WEST SUSSEX COUNTY COUNCIL CONSULTATION

TO:	Arun District Council FAO: Amber Willard
FROM:	Highways, WSCC
DATE:	14/11/2018
LOCATION:	414, Chichester Road, Bersted, Bognor Regis, PO21 5DR
SUBJECT:	BE/104/18/HH Loft conversion with new gable & dormer to rear.
DATE OF SITE VISIT:	N/A
RECOMMENDATION:	☒ Advice ☐ Objection ☐ Modification ☐ No Objection ☐ More Information ☐ Refusal
S106 CONTRIBUTION TOTAL:	£N/A

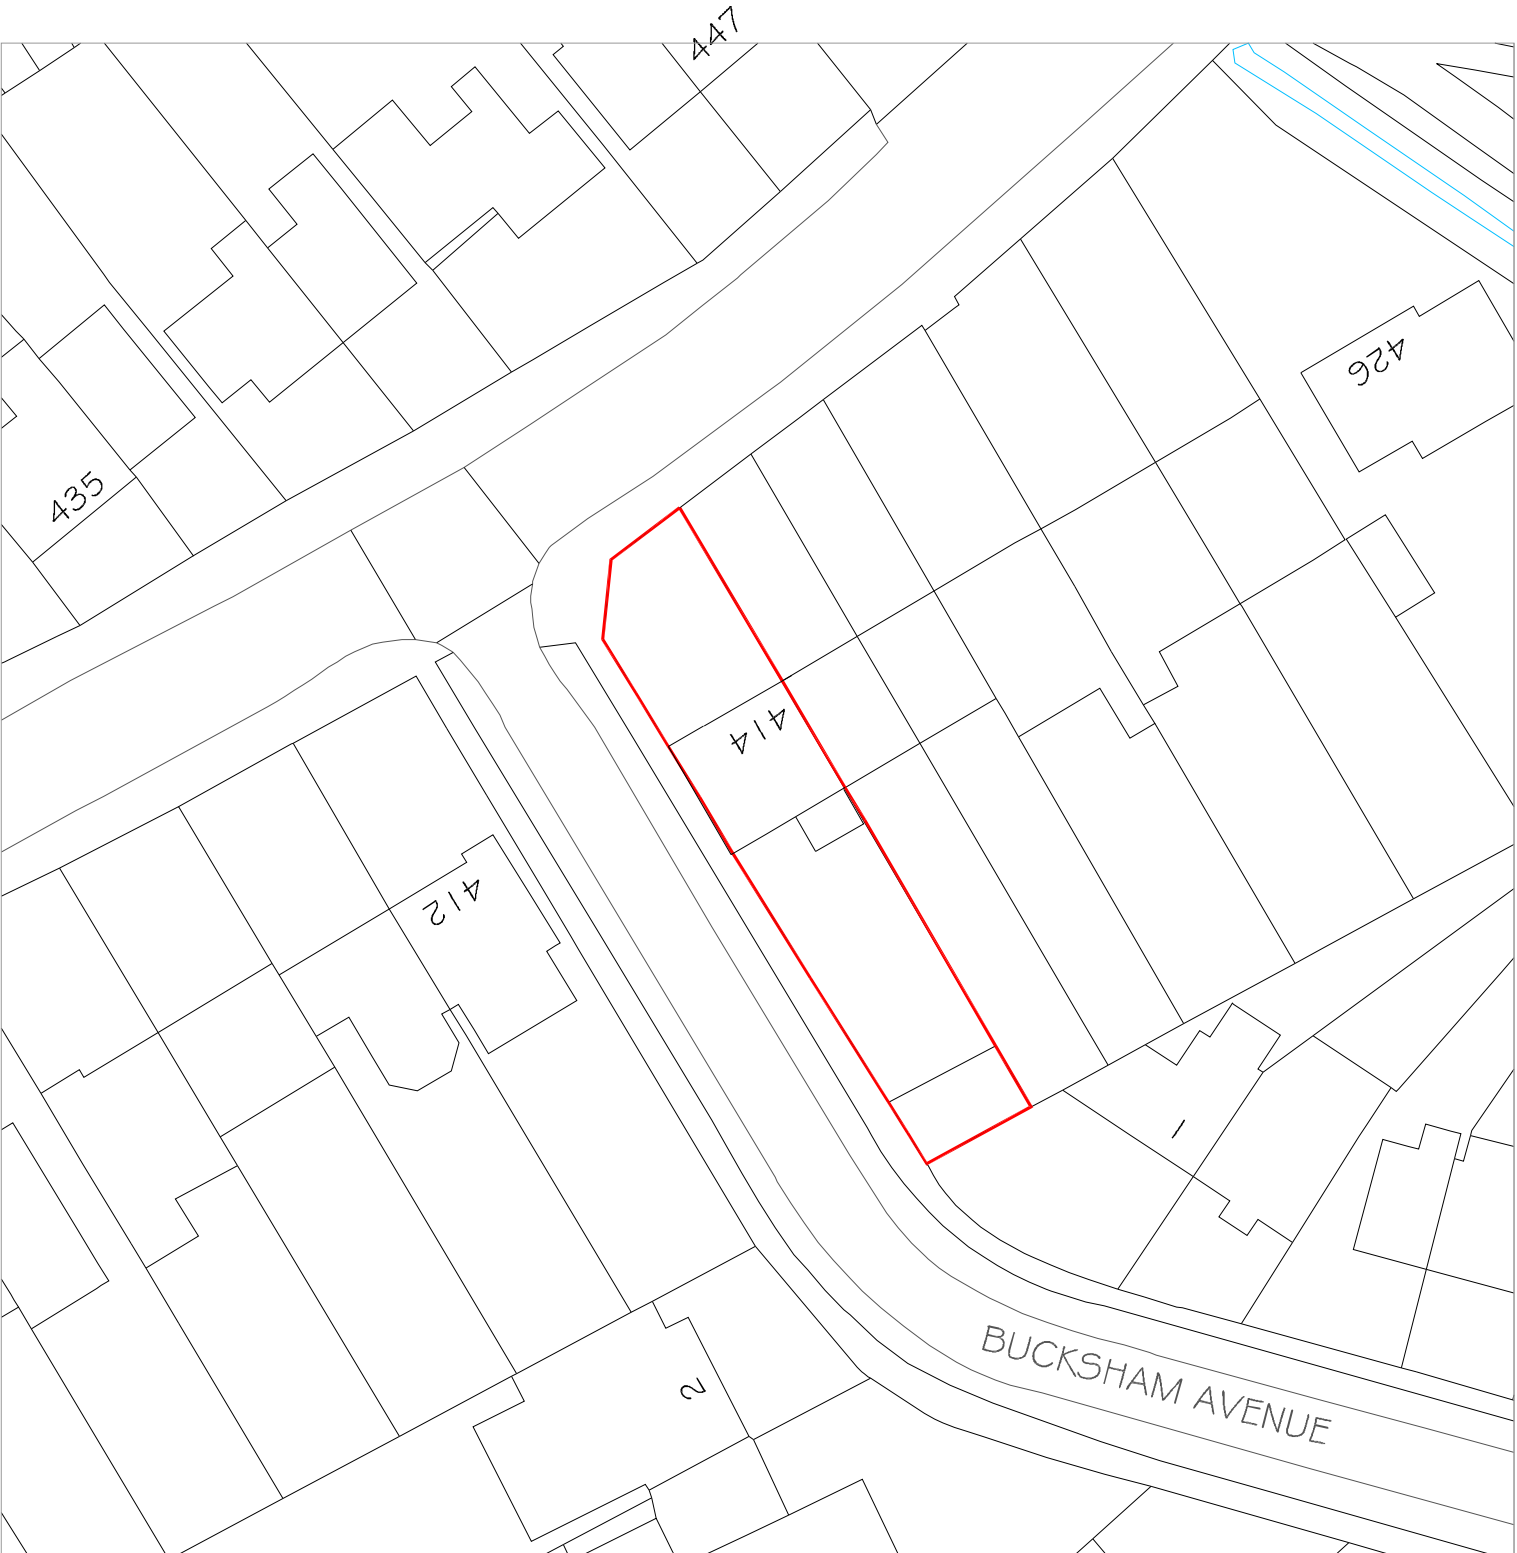
The plans indicate that the proposed vehicular access (VCO) will be from Bucksham Avenue, an unclassified, no-through residential road subject to a speed limit of 30mph. The proposed access is approximately 4.5m wide at the road edge. A licence is required for the proposed VCO and must be constructed to a specification agreed with the Local Highway Engineer. As local mapping indicates that the site currently benefits from an existing VCO serving the garage to the rear of the site, the Local Area Engineer was consulted on this application. The Area Engineer has confirmed that this area is subject to a policy that a licence *would not be granted* for a second crossover to any property, due to the existing parking pressures and the potential loss of on-street parking provision for neighbouring residents.

Vehicular visibility splays for the proposed access have not been demonstrated; however visibility appears sufficient for the anticipated road speeds in this location. Due to the proximity to the junction and the presence of on-street parking vehicles are not anticipated to be travelling at the posted speed limit in this location. Furthermore, WSCC mapping indicates that visibility splays are maintainable wholly within the highway boundary in this location. An inspection of data supplied to WSCC by Sussex Police over a period of the last five years reveals that there have been no recorded injury accidents within the vicinity as result of the road layout, and as such, it is not anticipated that the addition of a VCO in this location would exacerbate an existing safety concern.

The site currently has access to the rear of the site, providing the potential for one vehicle to park off-street. The applicant proposes one additional off-street parking space for the dwelling; this space meets the minimum specifications of 2.4 x 4.8m as set out in MfS. The proposed loft conversion will

result in an increase in dwelling size from 3-bedrooms to 4-bedrooms. The WSCC car parking demand calculator expects that a minimum of 2 spaces would be required for a dwelling of this size and location. The LPA may wish to consider the impacts of this proposal on on-street car parking from an amenity point of view. The proposals do not include the provision of a turn on site; however, neighbouring properties have similar arrangements and appear to have been operating without evidence of safety concern.

No part of the development shall be first occupied until such time as the vehicular access serving the development has been constructed in accordance with the approved planning drawing.

No part of the development shall be first occupied until the car parking has been constructed in accordance with the approved site plan. These spaces shall thereafter be retained at all times for their designated purpose.
